Port Talbot Power – ExA’s First Round of Questions

18th December 2014

THE PORT TALBOT STEELWORKS (POWER GENERATION ENHANCEMENT) ORDER  
 INDICATIVE ELEVATIONS – GENERATING STATION PHASE 1 OF OPTION 2

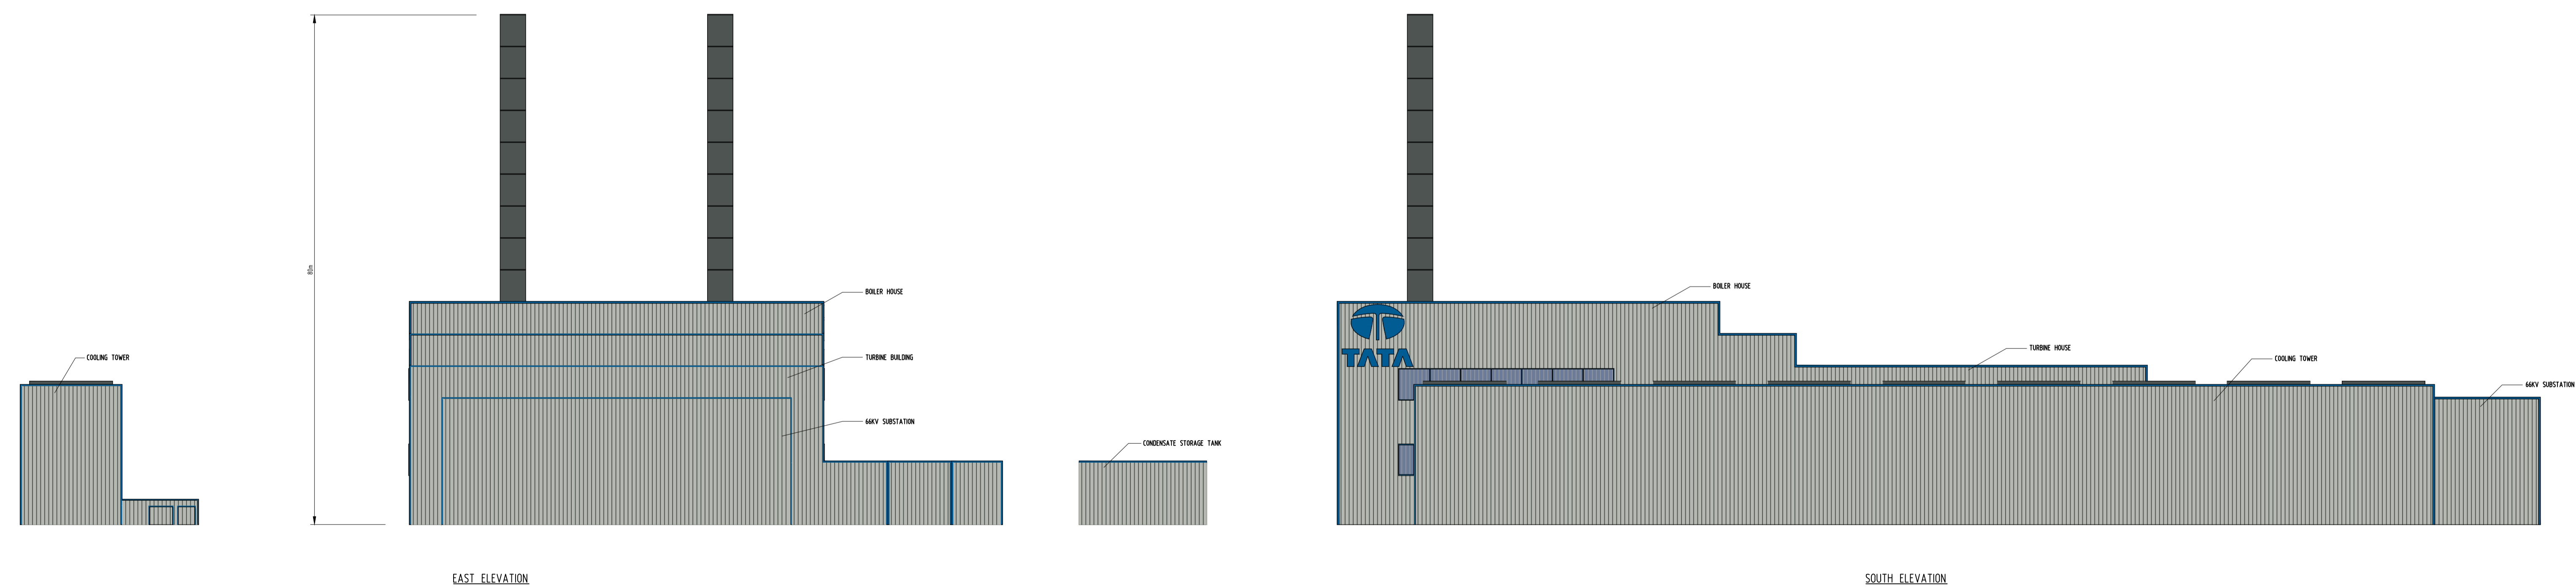
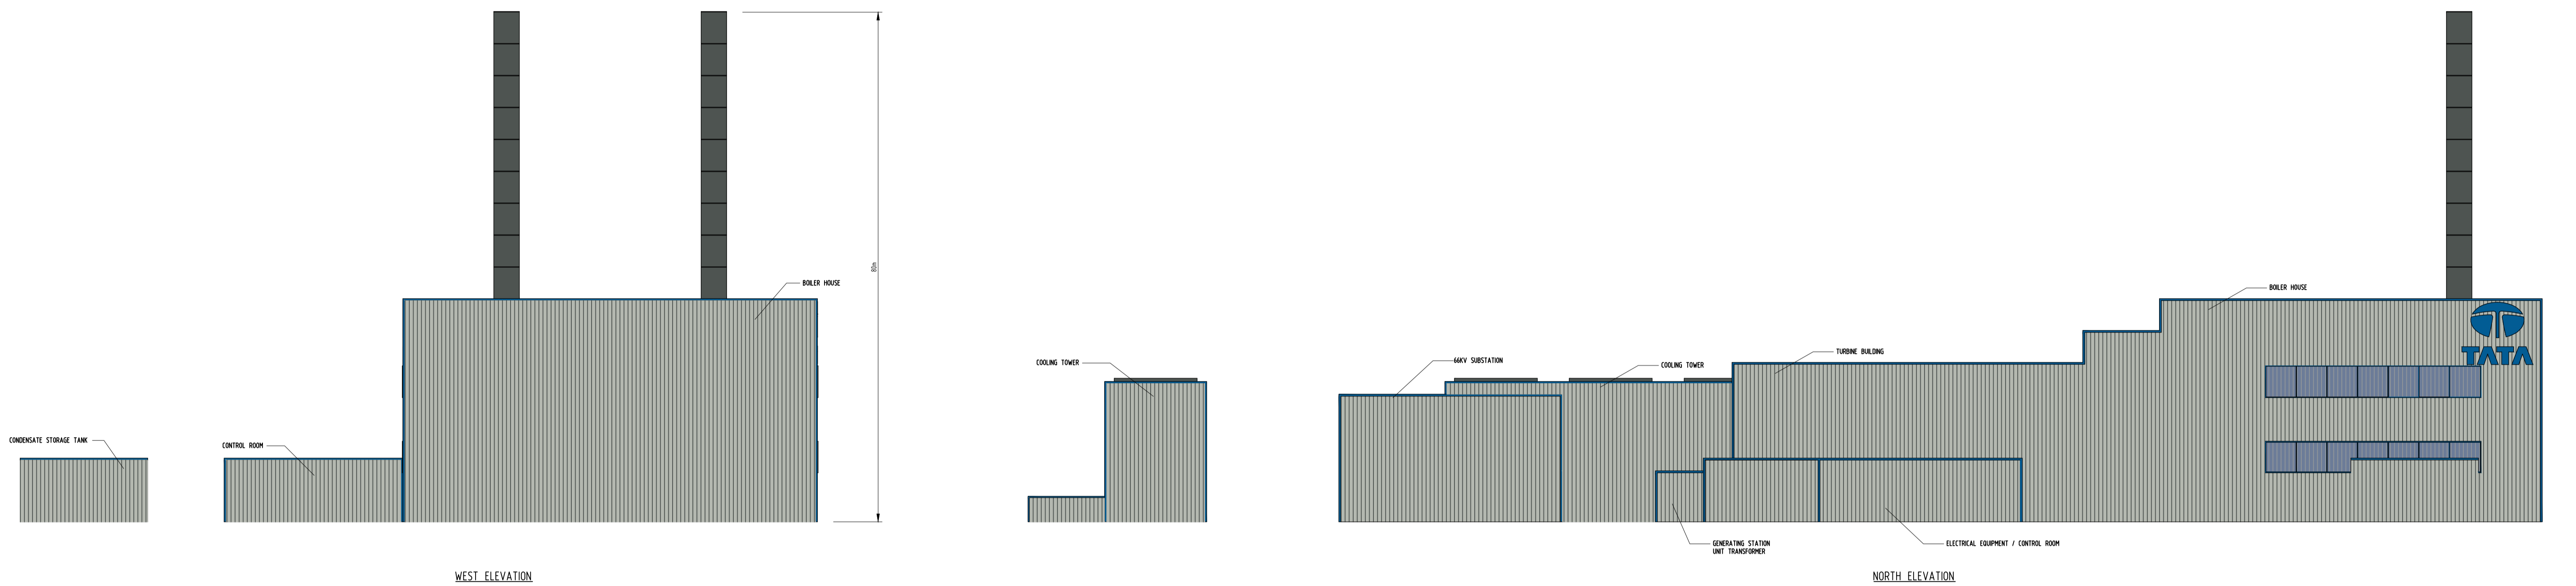
- d) Can the **applicant** provide a table of dimensions for Option 2 Phase 1
- e) Can the applicant propose revised drafting for DCO Schedule 2 Requirement 4 (2) (b) which ensures the maximum dimensions are not exceeded.

Client: **THE PORT TALBOT STEELWORKS (POWER GENERATION ENHANCEMENT) ORDER**  
 Project:  
 Title: **INDICATIVE ELEVATIONS - GENERATING STATION**

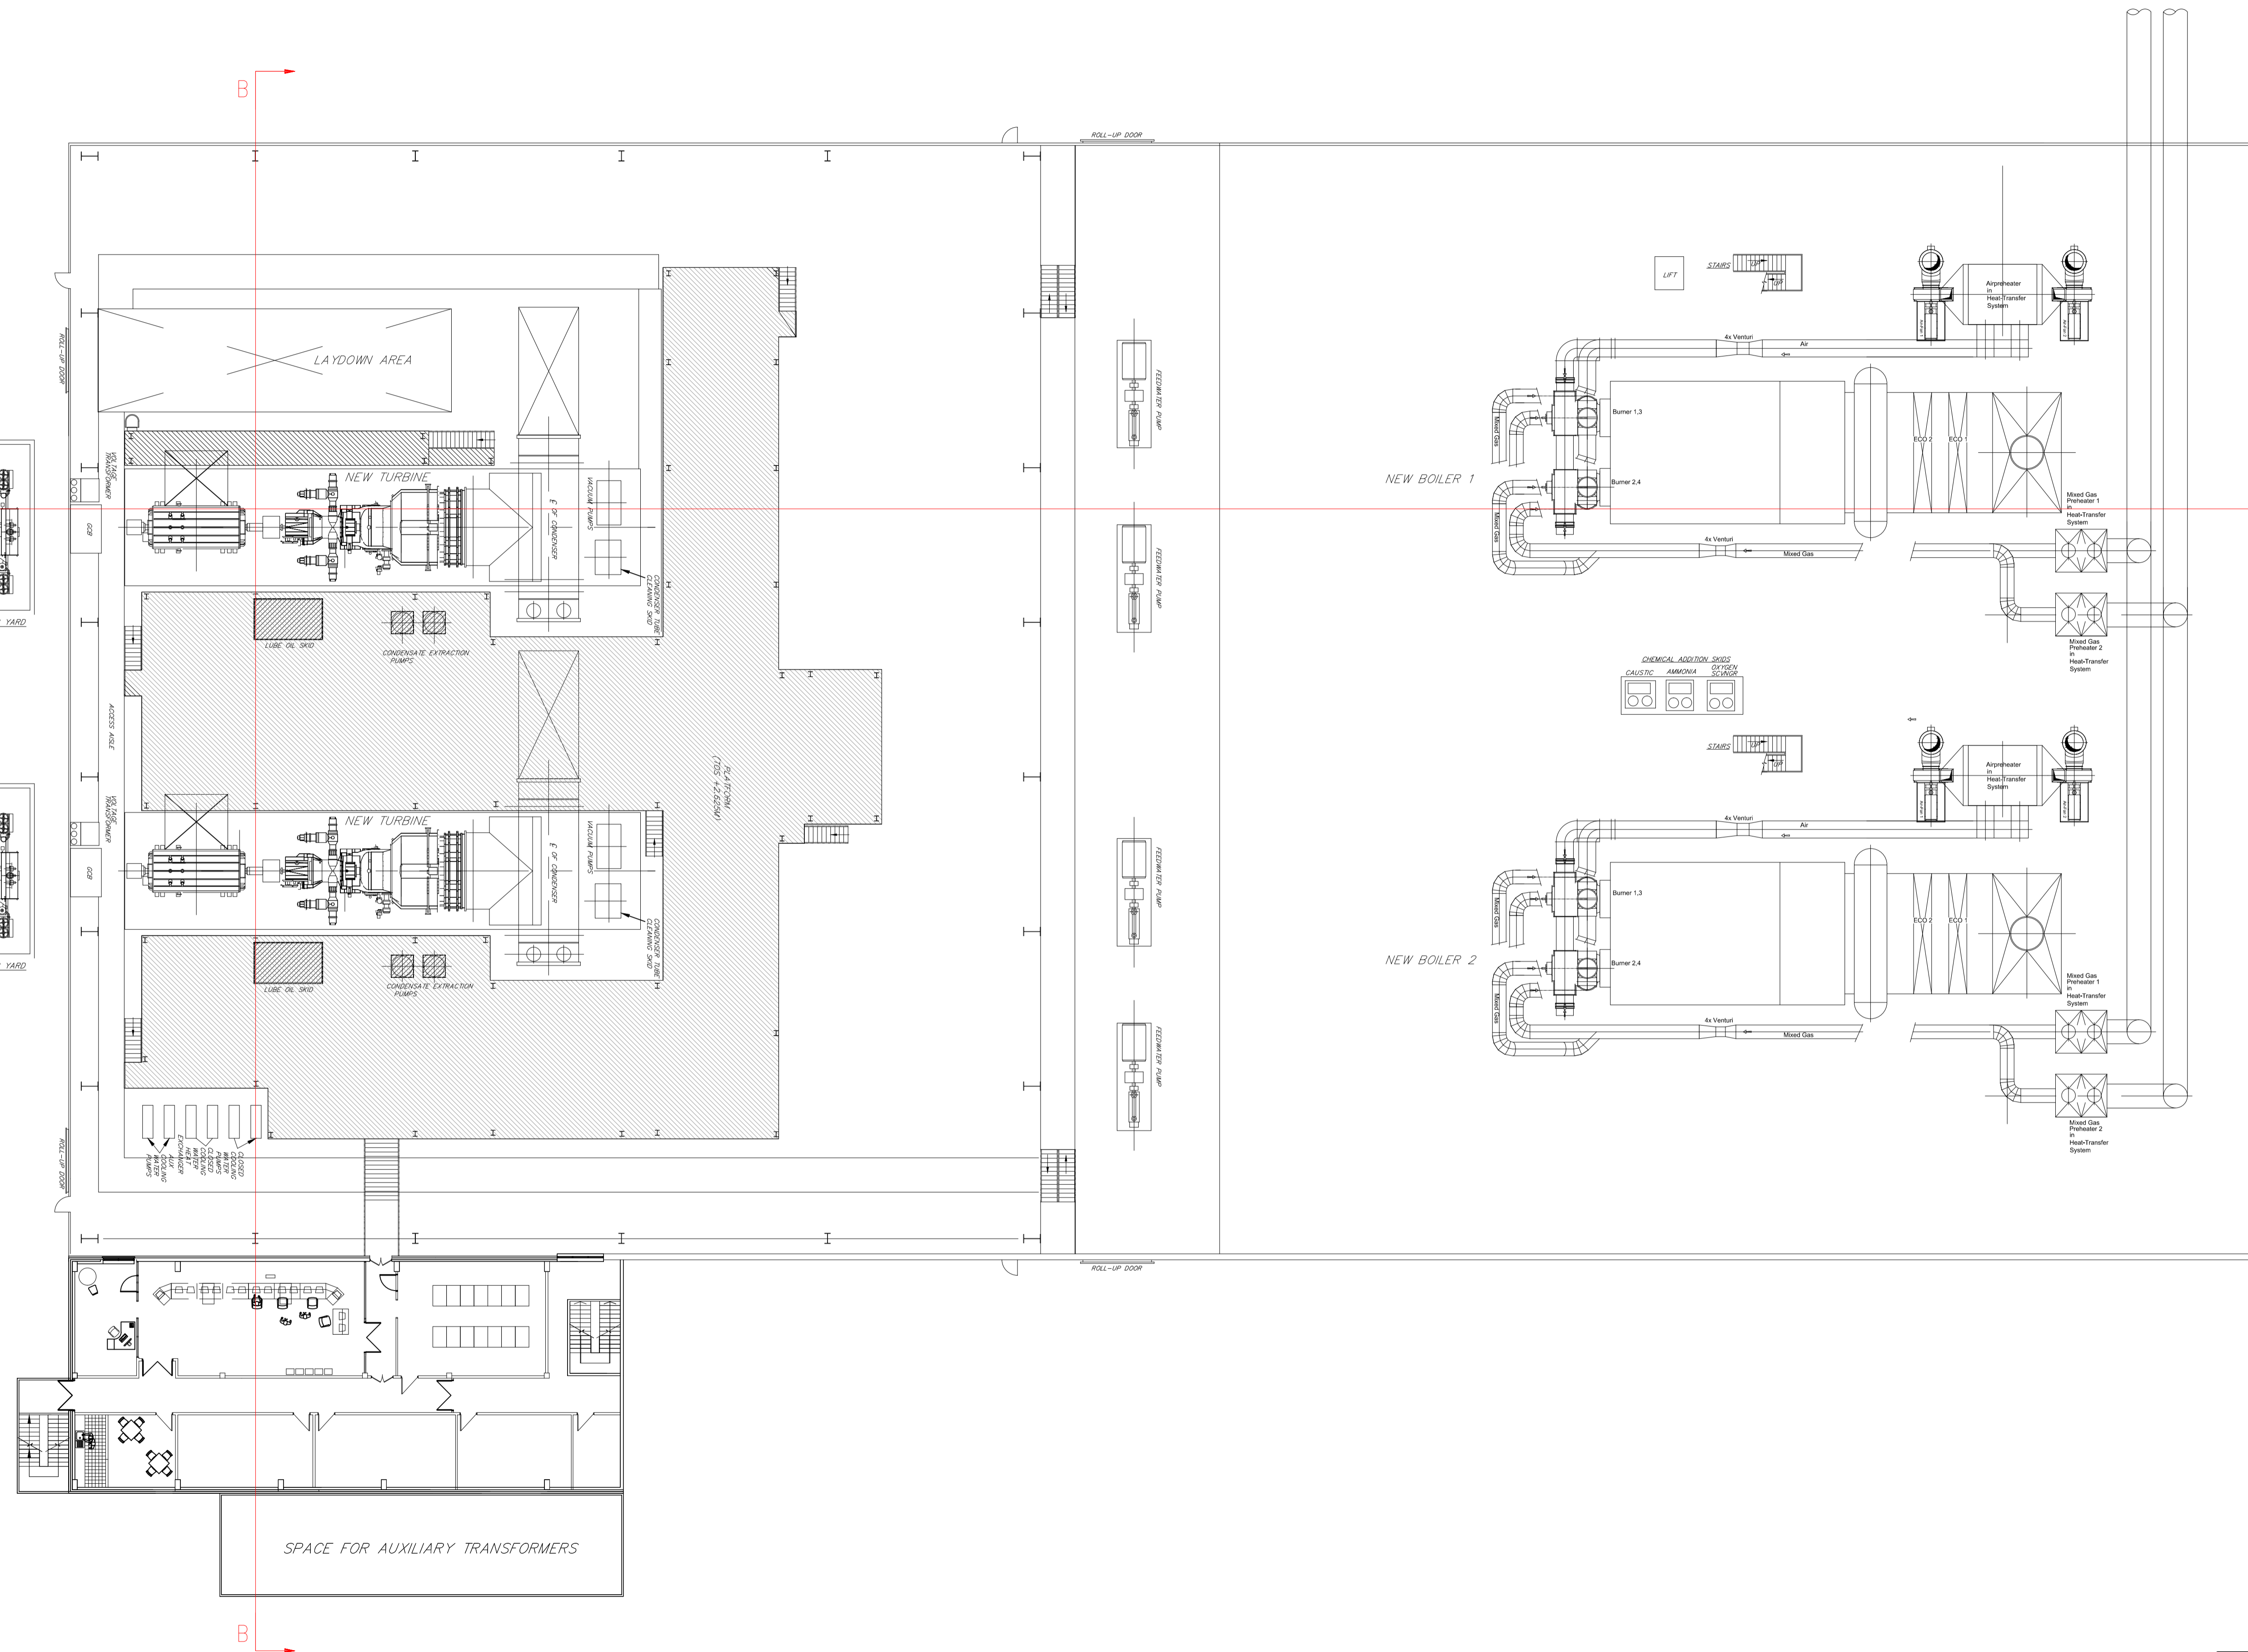
- a) Can the **applicant** provide evidence to support their assertion that the changes to the Turbine Hall and Cooling Tower Units width dimensions are due to "design optimisation".

- b) Can the **applicant** provide evidence to support their statement that the changes to the Turbine Hall and Cooling Tower Units width dimensions are as a result of Statutory Undertaker comments.
